Holme Valley Parish Council

Planning applications lodged with Kirklees from **02 05 2022** to **31 05 2022** - **List 2223-02**. The following applications will be considered by Holme Valley Parish Council ahead of the Planning Committee meeting **06/06/2022**. Where appropriate, recommendations will be made to Kirklees Planning Services regarding whether or not they should be approved, but the final decisions will be taken by Kirklees Planning Services.

Proposed Site Layout
Scale 1:200

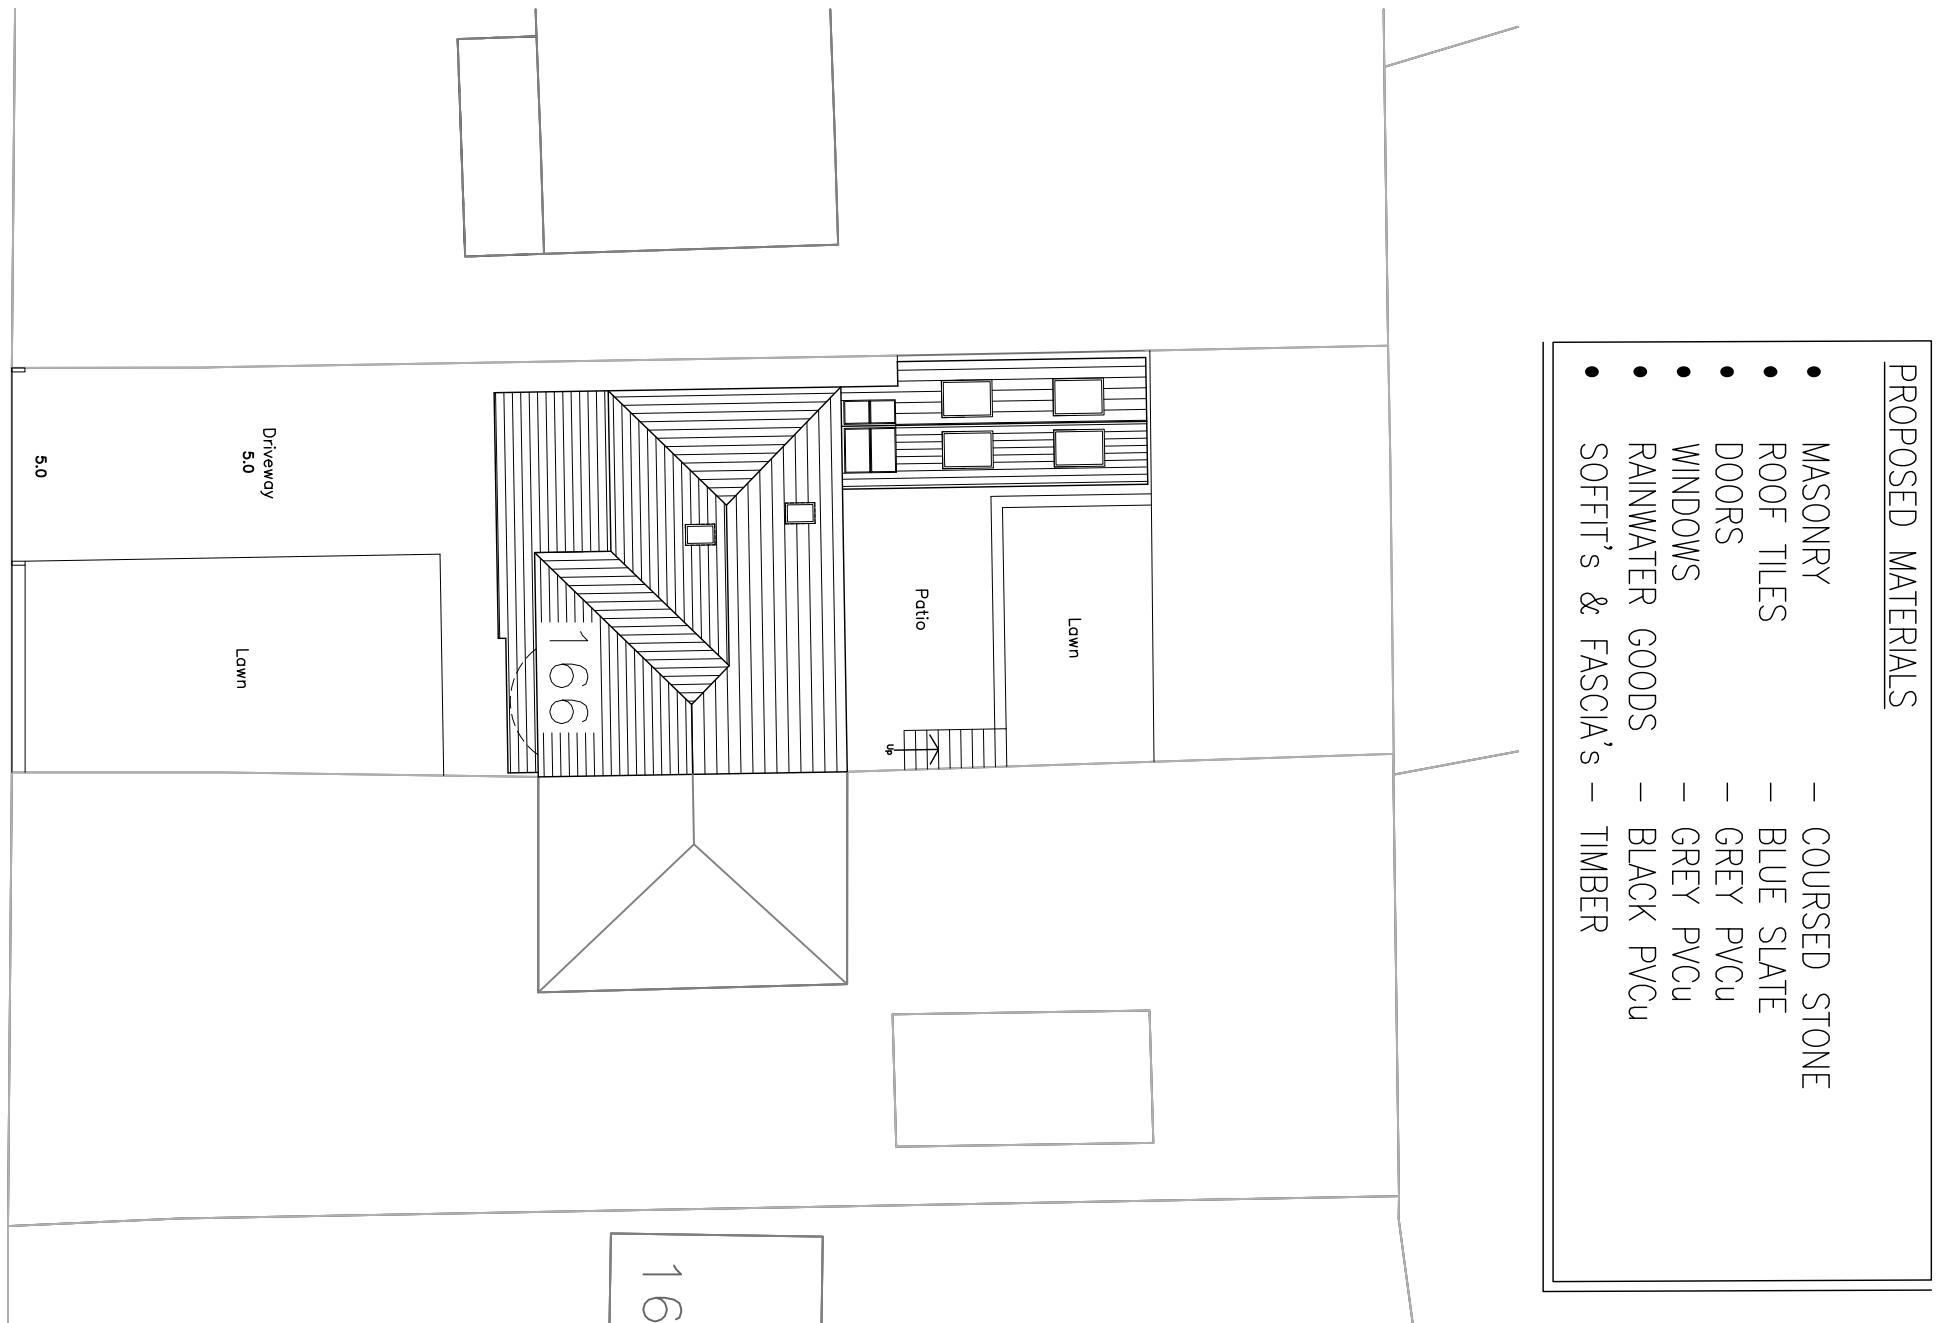
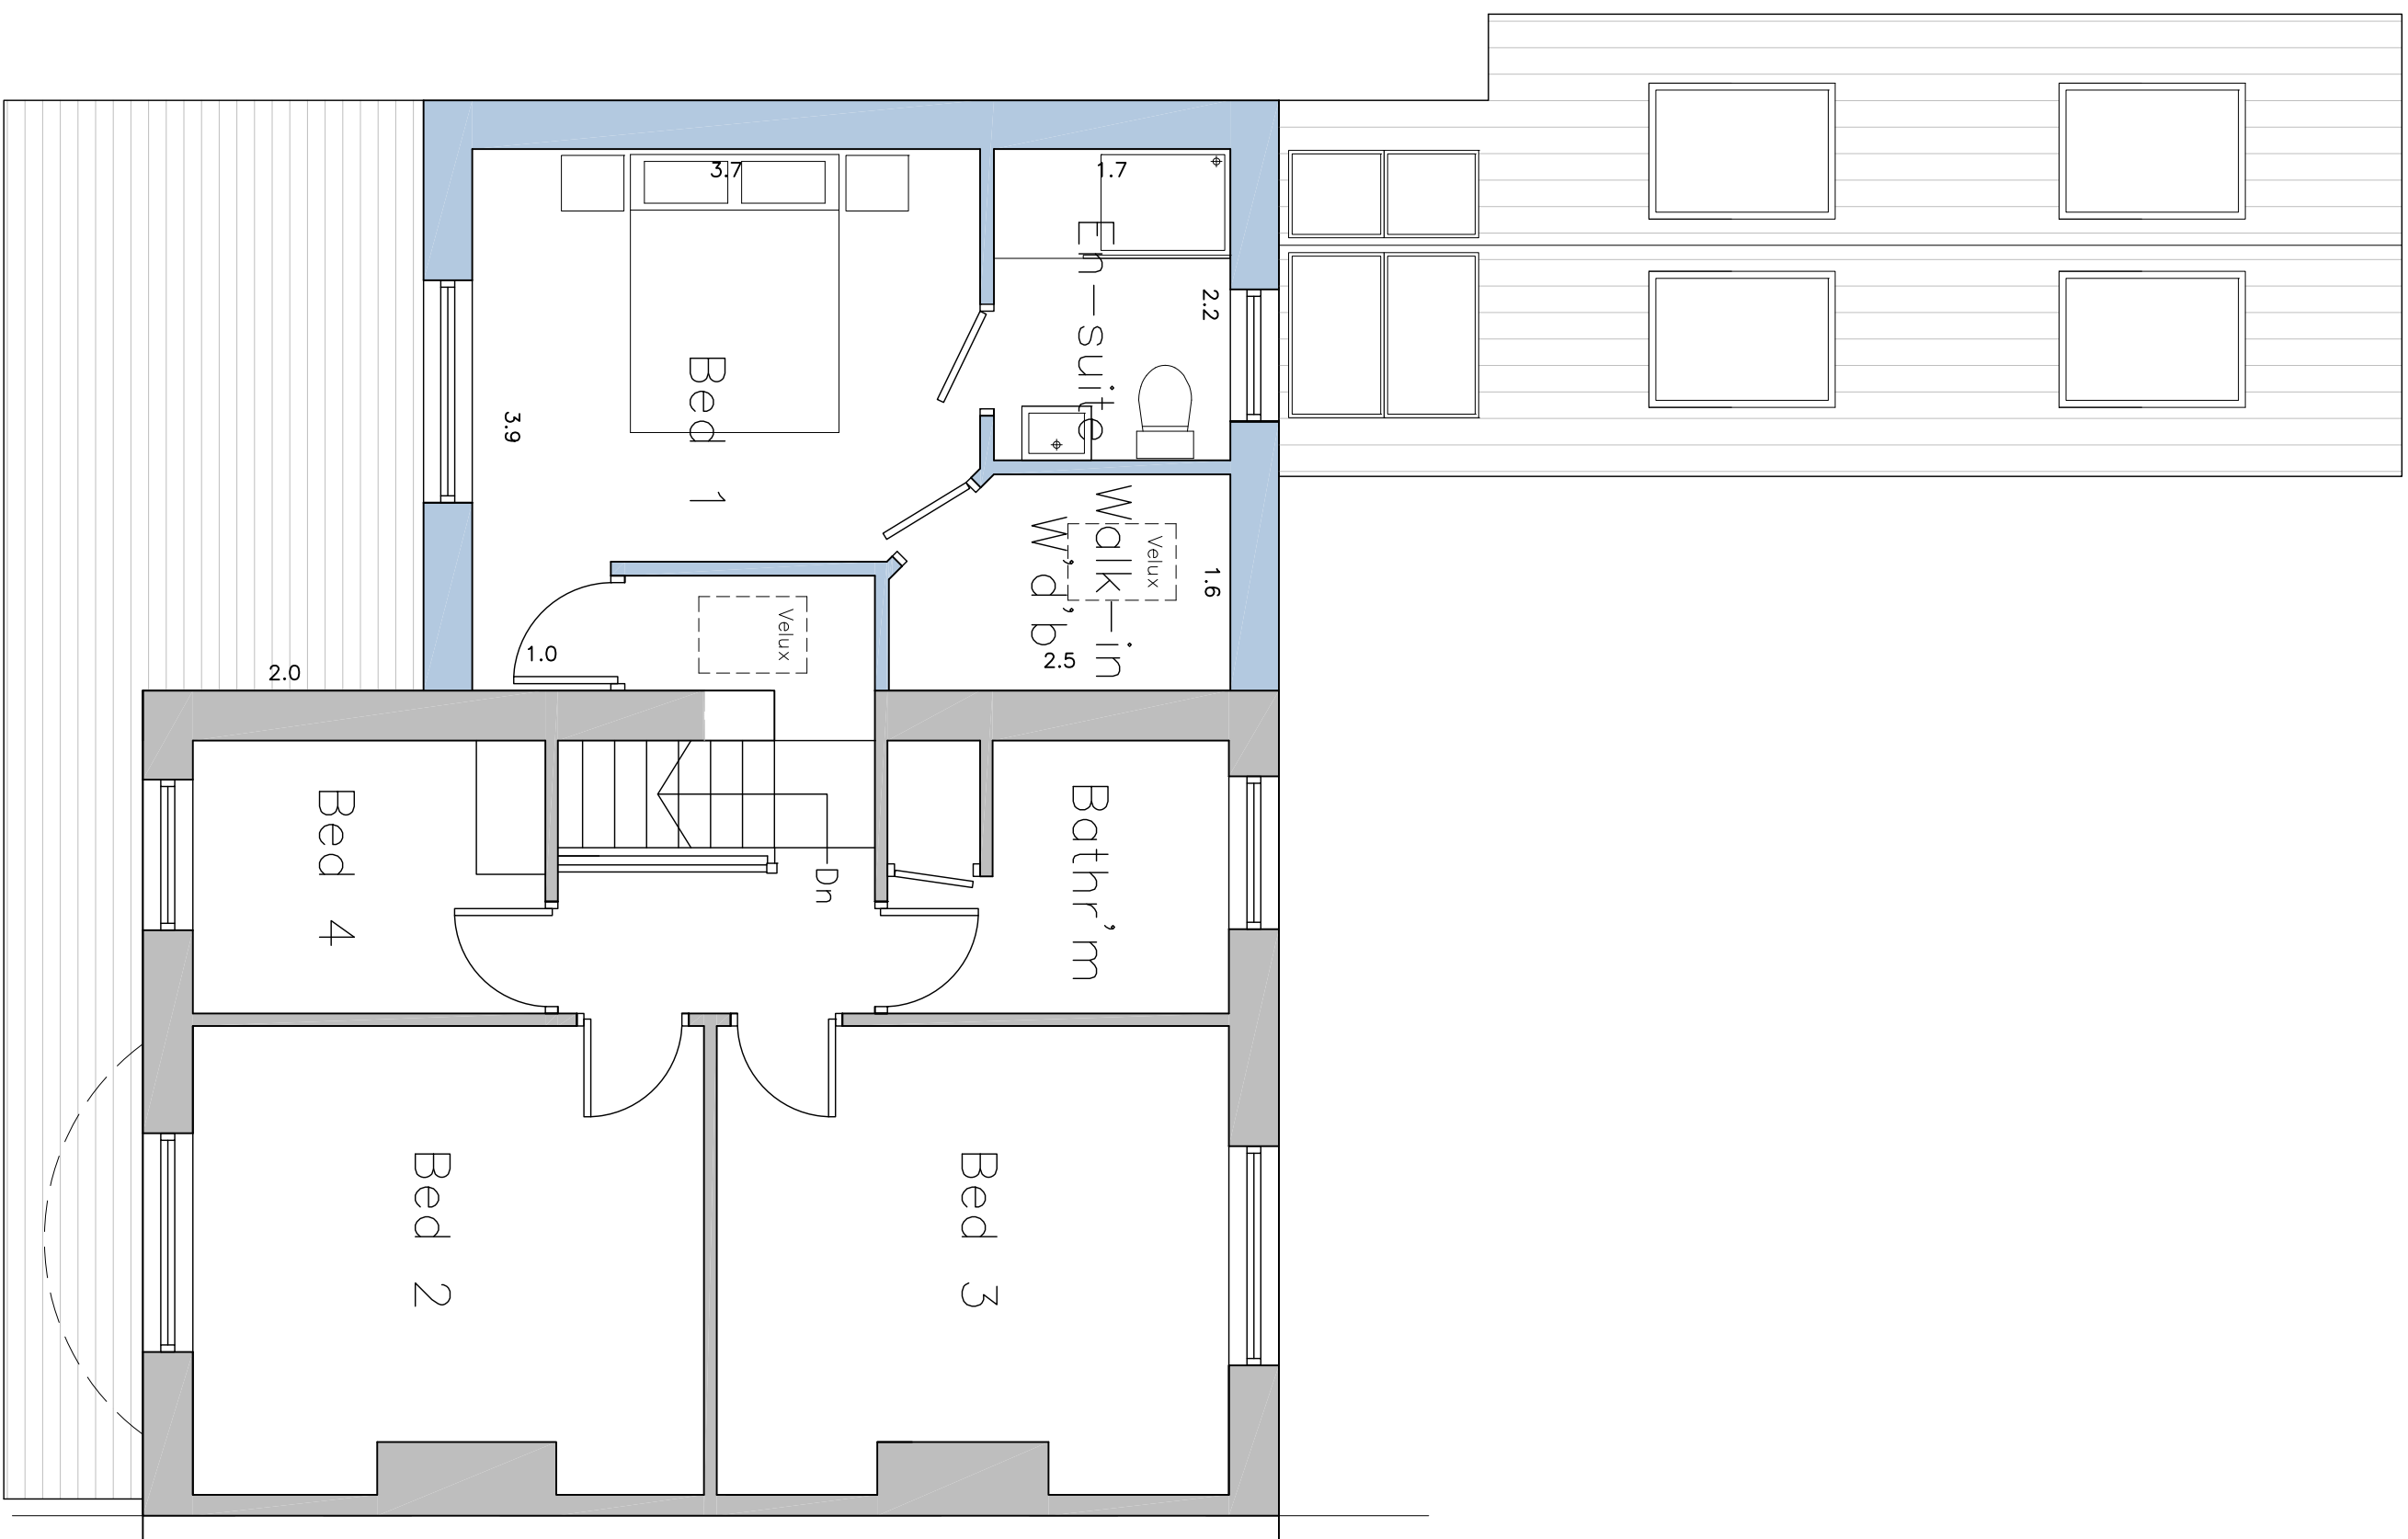
HVPC Reference:	2223/02/08
Application No:	2022/62/91467/W
Proposed Development:	Erection of two storey side extension single storey front extension with raised terrace above, conversion of existing garage and erection of link structure and alterations to existing raised lawn/seating area to rear
Location:	166, Greenfield Road, Holmfirth, HD9 2LP
OS Map Ref:	SE 412882.116408012.7367
Link:	http://www.kirklees.gov.uk/beta/planning-applications/search-for-planning-applications/detail.aspx?id=2022/91467
Ward/Councillors:	Upperthong - DC AW
HVPC Comment:	Oppose. The extension is too large, is right up to the property border, and there is no access to the rear. Plans are not clear on the provision of adequate parking.
Decision:
